RE: DRAINAGE PLAN FOR BROADWAY COMMERCIAL  
(M-14/~~17~~) ENGINEER'S STAMP DATED NOVEMBER 17, 1986

RE: DRAINAGE PLAN FOR BROADWAY COMMERCIAL  
(M-14/123 RECEIVED NOVEMBER 11, 1986)

GRADING AND DRAINAGE PLAN

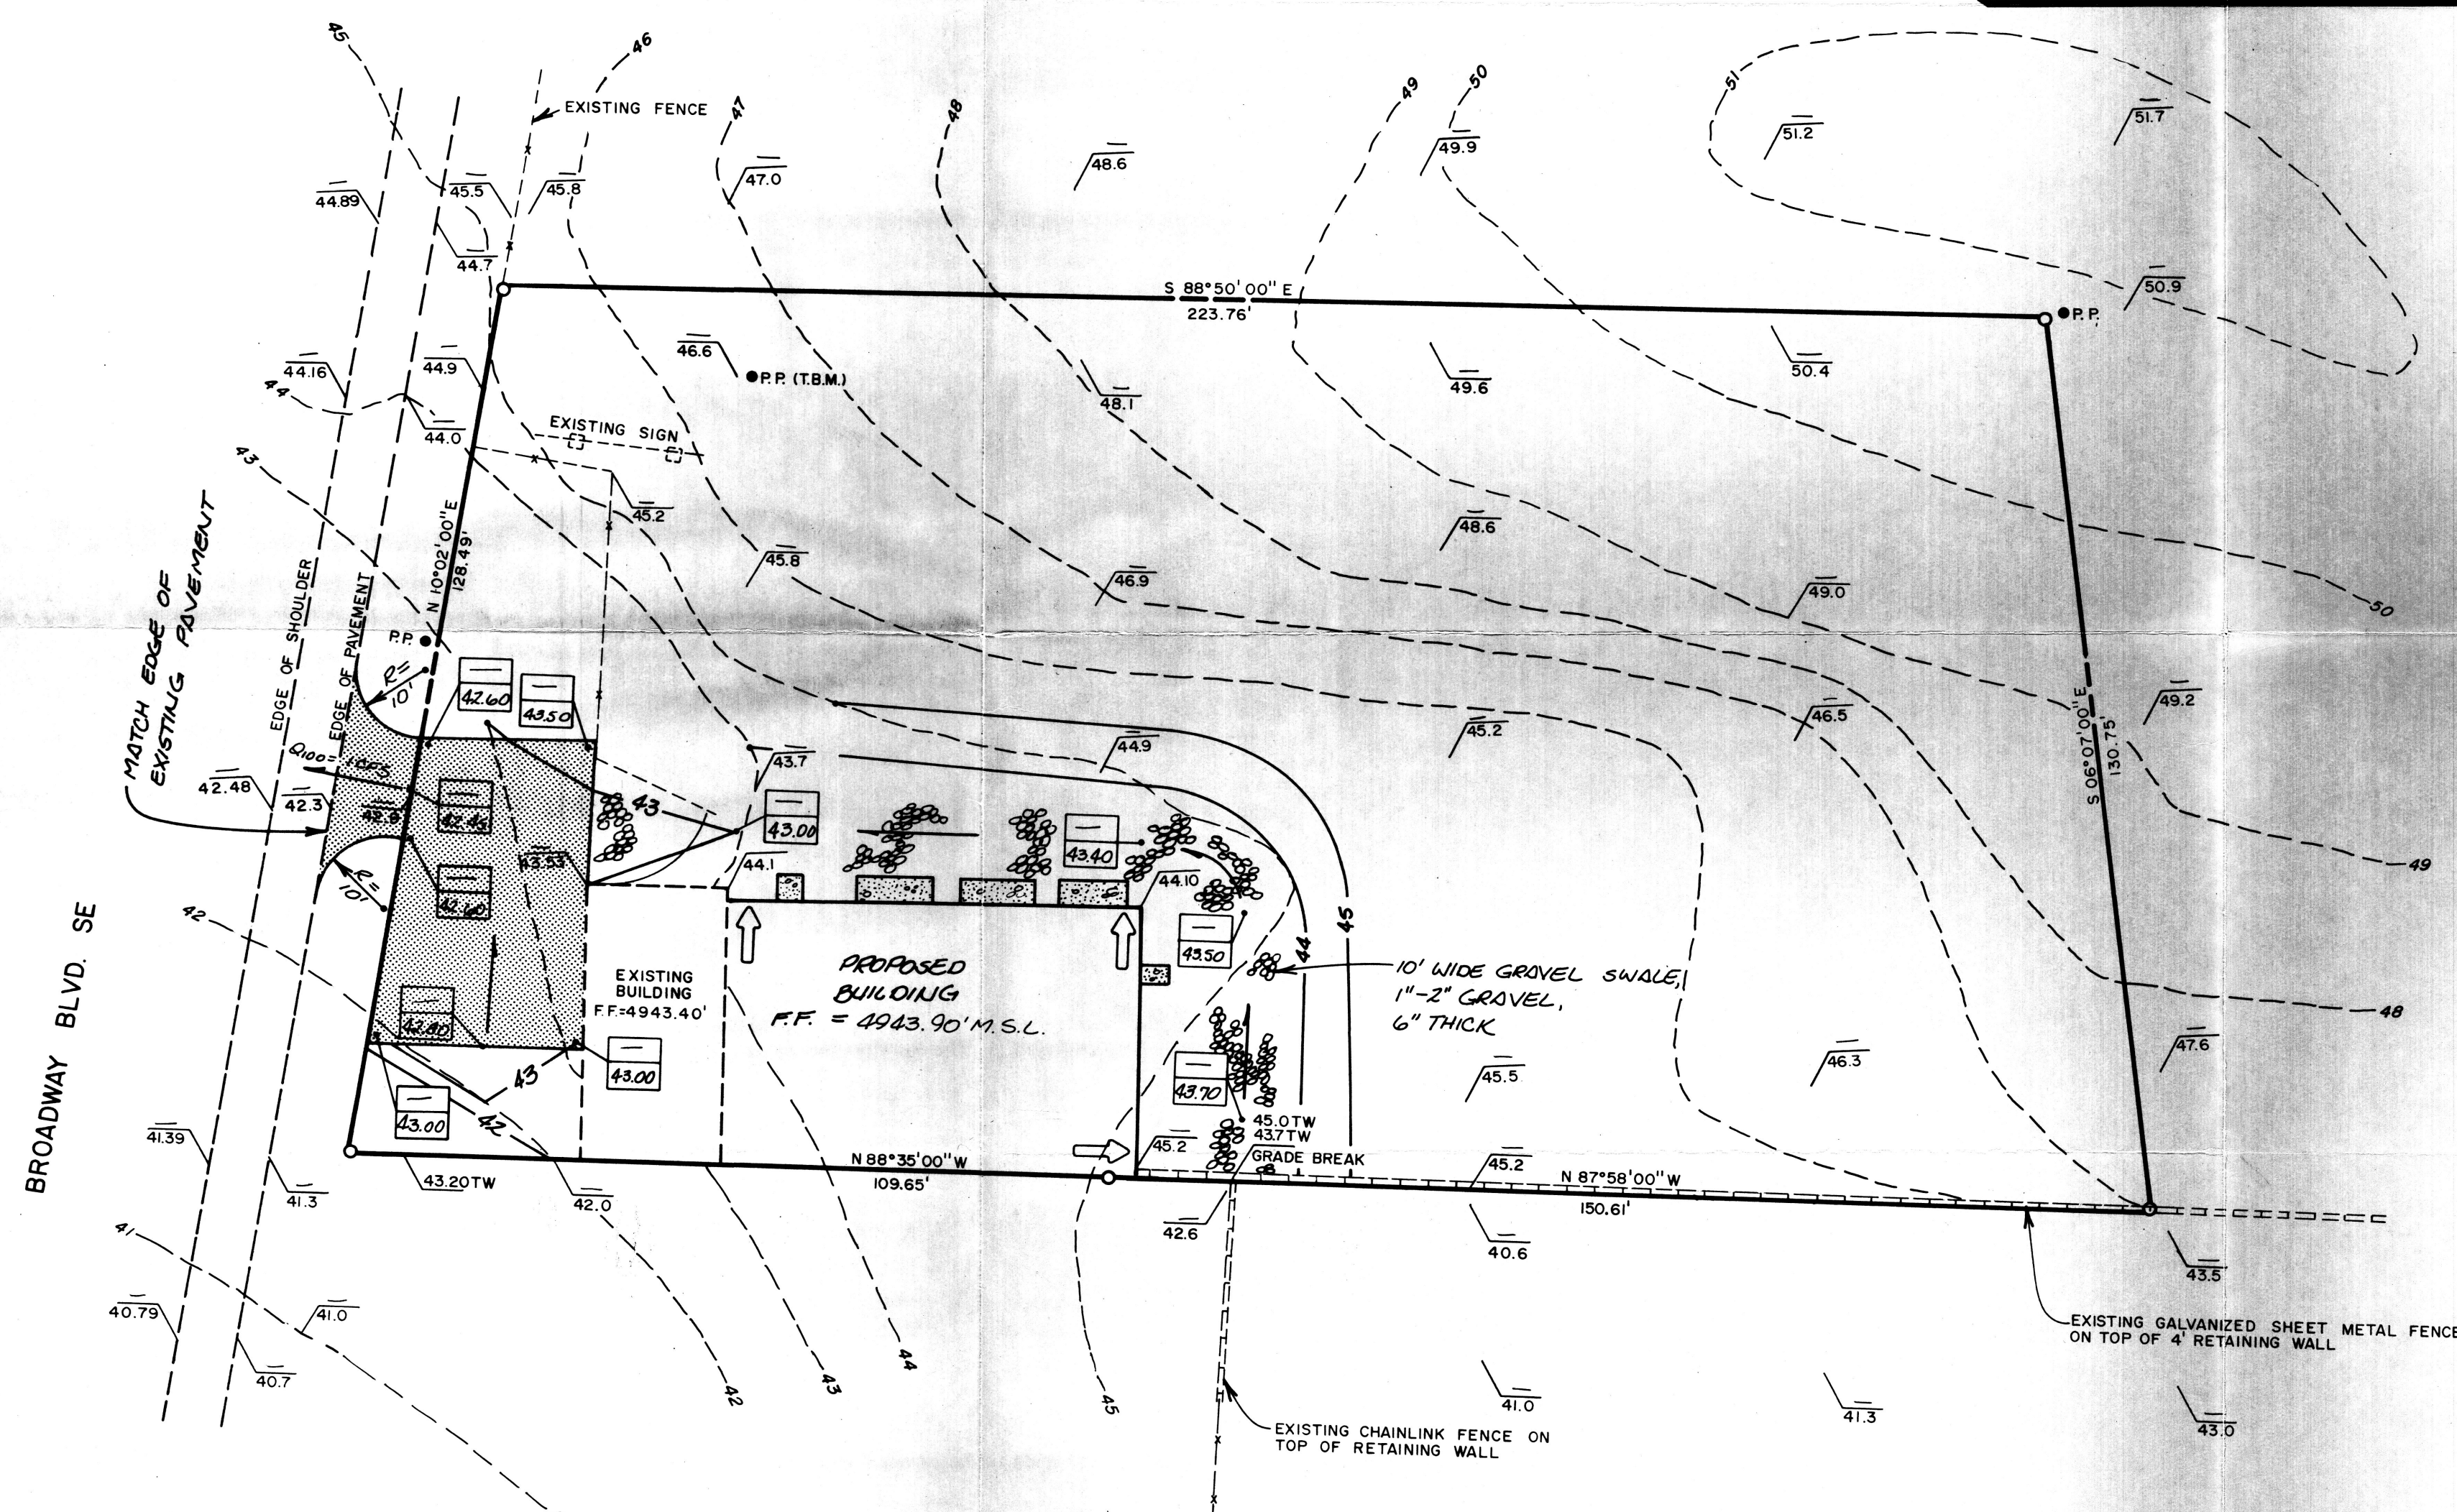
1. You will need to direct the runoff thru the curb cut/drive pad.
2. Please include your undeveloped, developed flow rates and volume calculations on the plan drawings.
